Ref: 6/2021/1643/HOUSE  
Date: 04/09/2021

## HISTORIC BUILDINGS AND CONSERVATION ADVICE

**RE: 159 Parkway, Welwyn Garden City, AL8 6JA**

The application is for the construction of 2 x rear dormers and 2 x front roof lights to facilitate the conversion of the loft to a habitable space.

6 Proposed Front Elevation
1 : 100

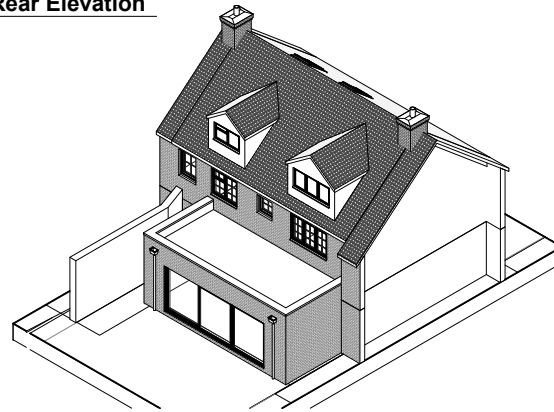
An objection is raised as the proposed rooflights and dormers detract from the uniformity and largely uninterrupted appearance of the roofscape of the terrace and the contribution it makes to the streetscape. The addition of these features undermines the character and appearance of the building and this part of the Conservation Area. Whilst the dormers are not visible from Parkway, the rear roof slope appears to be visible from Stanborough Close and, in any case, a lack of visibility from public areas does not equate to a lack of harm as the rears of buildings are seen from neighbouring gardens which are also within the Conservation Area. Dormers would be an incongruous feature to the terrace and the front rooflights are an unsympathetic addition to the streetscene.
